Inner West Council Response: SSD-78268465 – Newington College Redevelopment (Concept and Stage 1)

Property: 200-244 Stanmore Road and 221-235 Stanmore Road, Stanmore

Attachment A - Consolidated Inner West Council Officer comments SSD-78268465 – Newington College Redevelopment (Concept and Stage 1)

Level 6 (Rooftop)

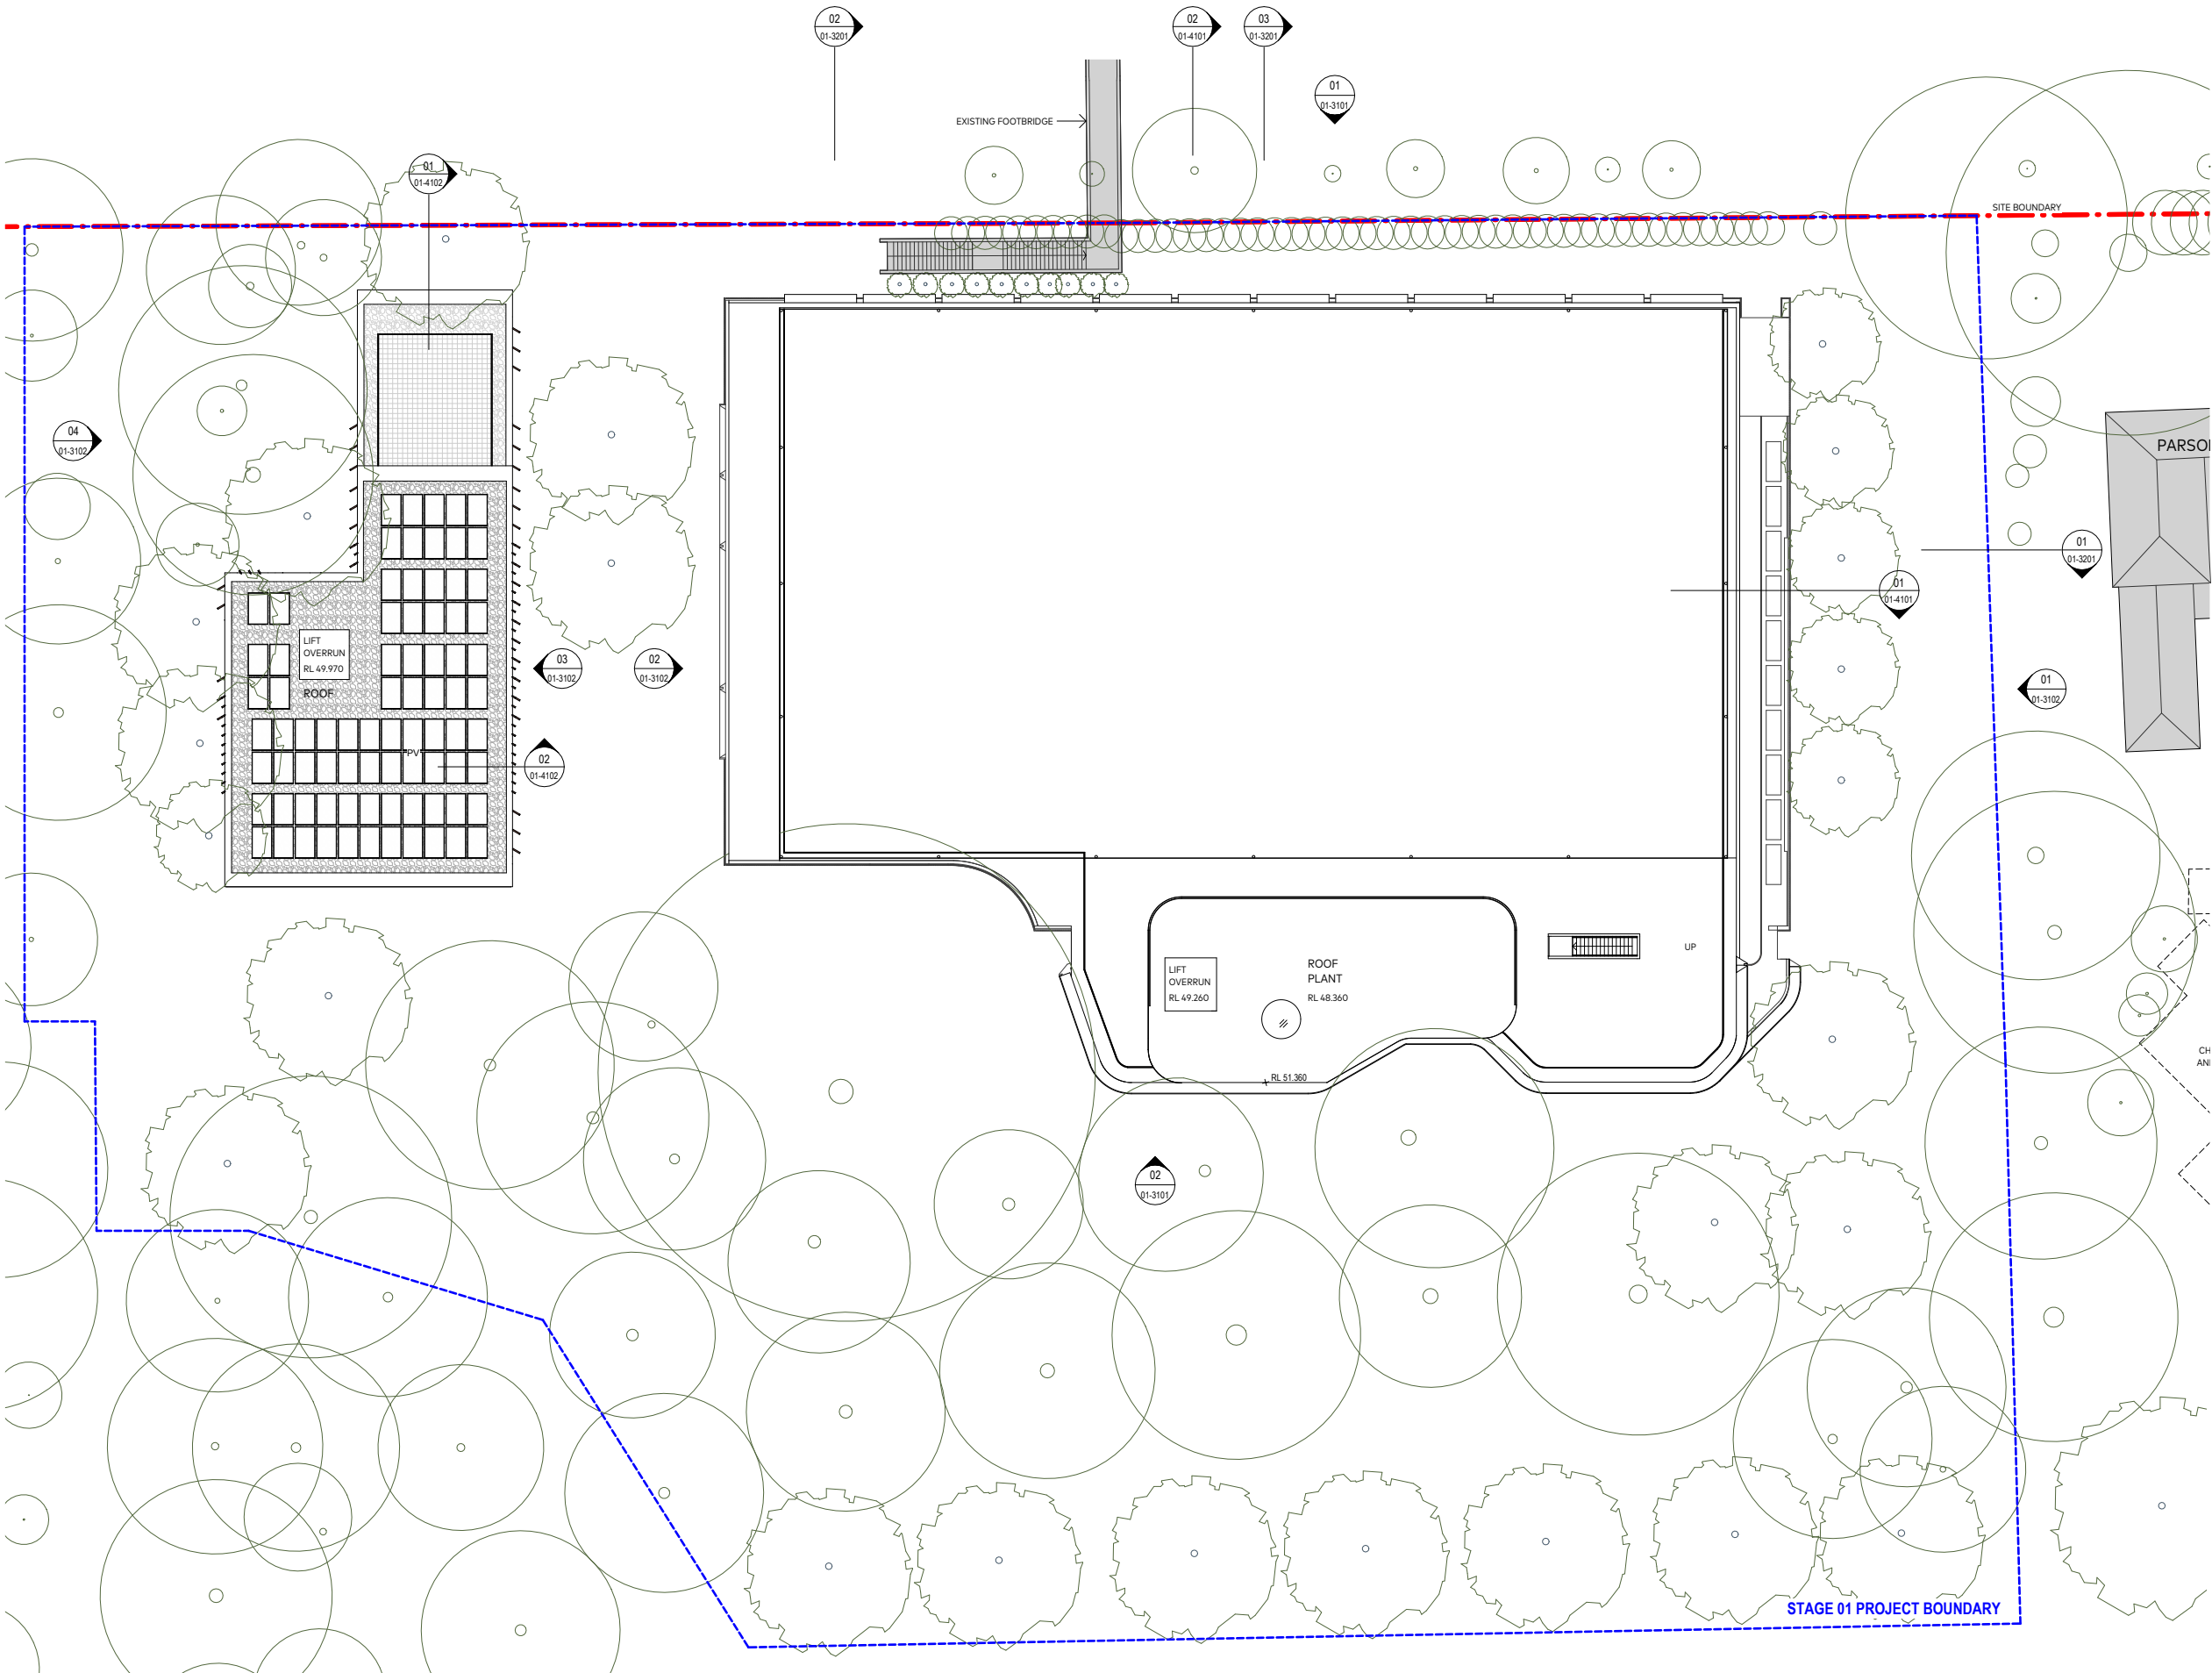
- c) Further clarification is required on the screening structure to the rooftop courts. It is unclear if the materiality is 07 or 11 or a mixture of both. Further, there appears to be

an angled detail to the corner of the courts which is unclear if it's a brace or chamfered edged or a change in materiality. Consideration should be given to increasing the setback of the screening structure from the Stanmore Road frontage to reduce any perceived visual bulk.

- d) Justification or refinement regarding the height of the roof plant structure on top of the Sevington Building.
- e) Clarification is required regarding the Stage 1 temporary car park and the proposed restoration of the site following completion of Stage 1. In particular, insufficient information has been provided to demonstrate what mechanisms are to be relied upon to ensure the temporary car park will be removed and the tennis courts and landscaping reinstated. Nor have any drawings been provided showing what the reinstated courts, fencing and landscaping will look like. A restoration plan and associated drawings is requested to confirm the final site layout and that a condition is imposed requiring all temporary works (such as the carpark) be removed prior to the occupation of the Sevington Building.

6.13 Elevation and Sections (Detailed Stage 1)

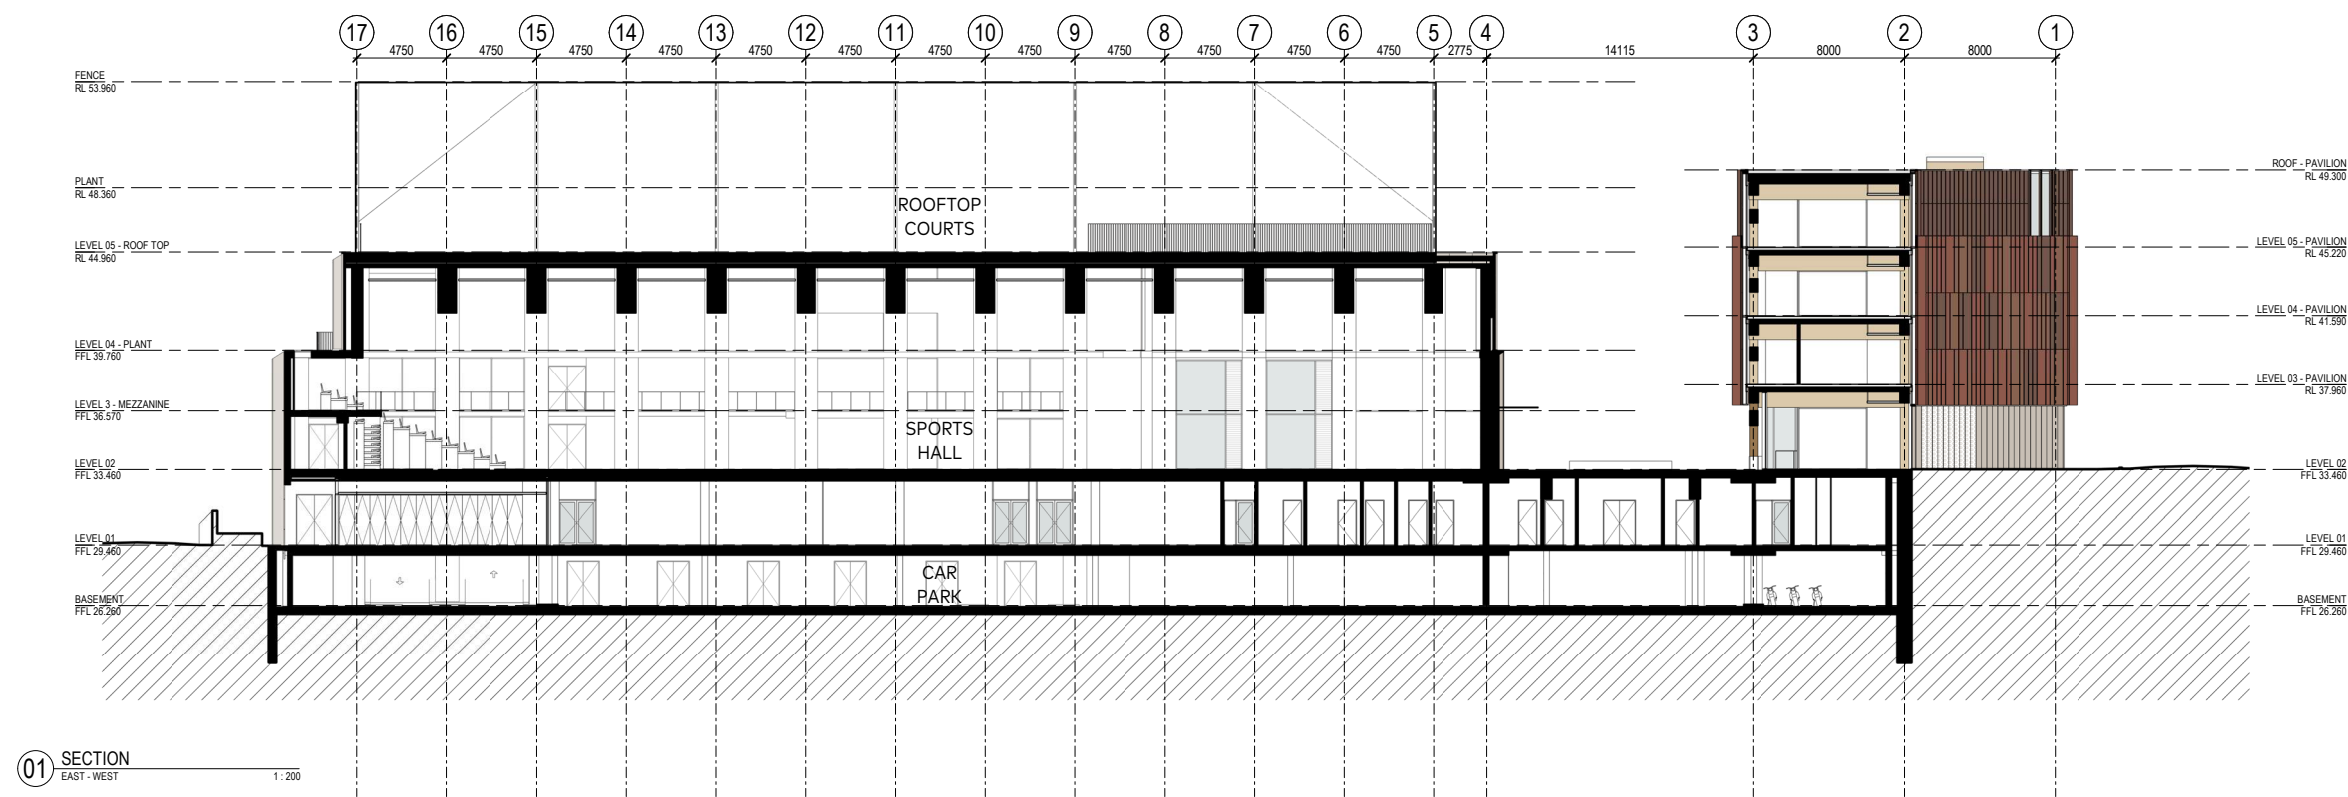
- a) Further refinement of the school's interface with Stanmore Road is required to better integrate with the surrounding streetscape and neighbourhood context. In particular, the northern and eastern elevation of the Sevington Building, which forms the primary façade to Stanmore Road, contains extensive blank wall areas. Given the building will be highly visible from the public domain and read in the round, all visible elevations require further design development to provide a more engaging and welcoming street presence. Greater visual permeability, activation and architectural articulation are required to improve the building's relationship with Stanmore Road and the surrounding public domain, particularly at a pedestrian level.

- b) The submitted materials and finishes schedule does not provide sufficient detail or consistency to confirm the intended final materiality of the building. In particular, discrepancies have been identified between the material schedule, material swatches, architectural elevations and visual representations. This includes the nomination of '03 Terracotta Cladding' to the lower levels and '04 Profiled Aluminium' to the upper level of the Sevington Building, which do not appear to align with the corresponding swatches or are represented inconsistently across the submitted documentation (images below showing three different finishes). Further clarification is required regarding the proposed materials, colours and finishes, including the provision of more realistic swatches and clear differentiation between alternative colour schemes (eg. 05a 05b to distinguish brown or green versions with the specific colour nominated). The cream colour on the corners of the north elevations is not annotated with a material or finish. The materials schedule should be referenced on the corresponding elevations to clearly identify the location and extent of each proposed material and finish.

7.3 Concordia Bridge Link - Elevation and Sections

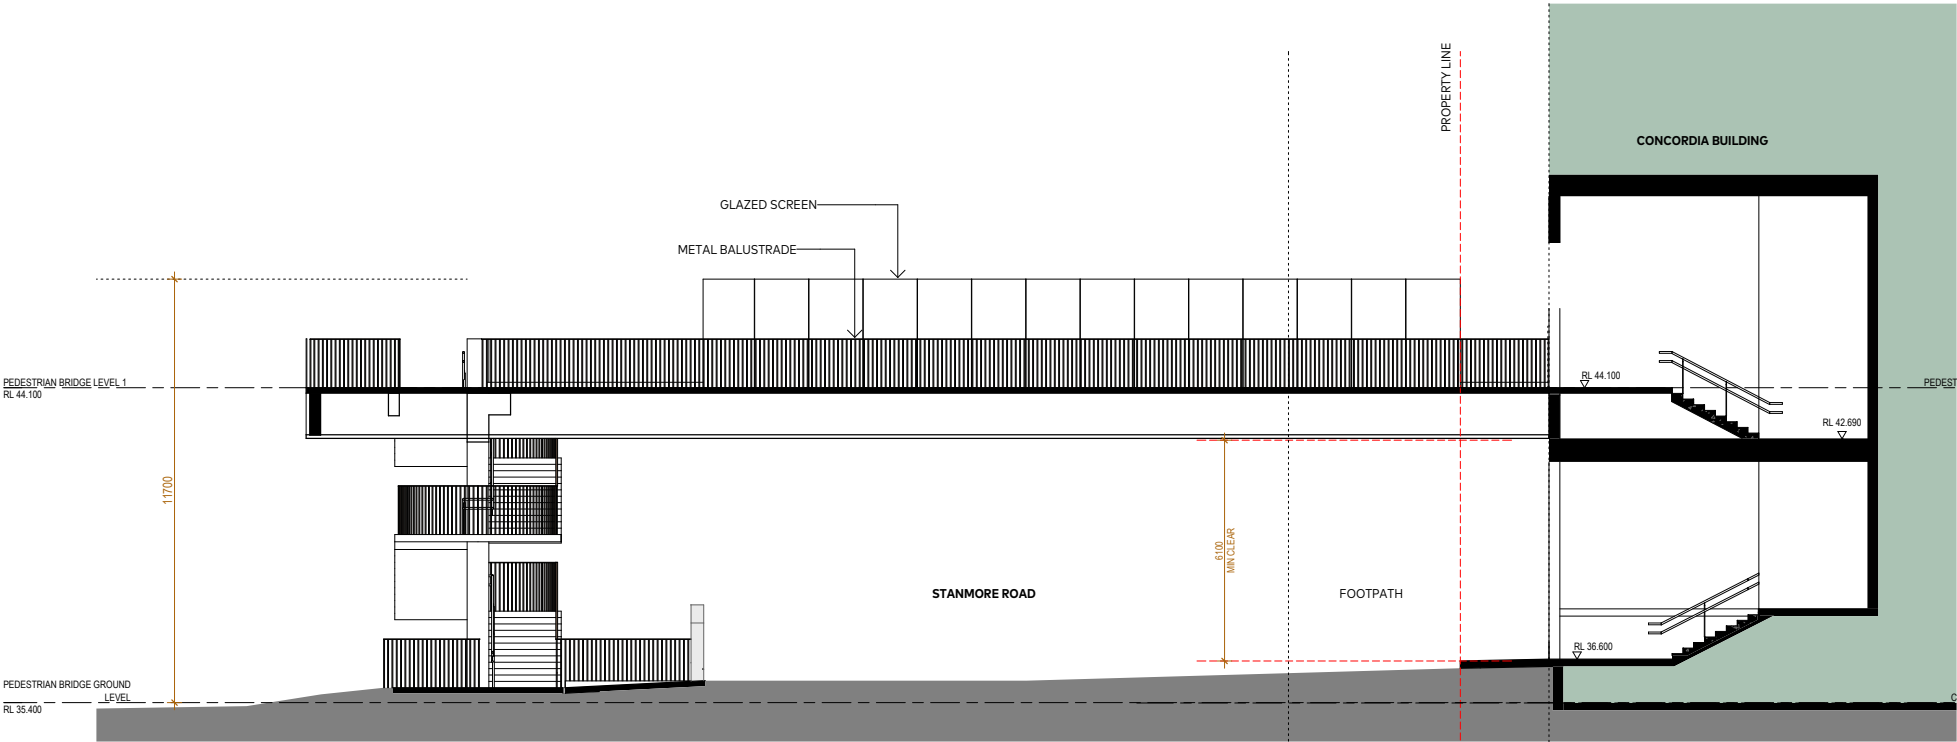
- d) Further consideration of the bridge lift design to ensure it is more clearly integrated into the public domain, highly visible and legible as a public facility. In this regard, it is recommended the entry is located closer to the public domain.
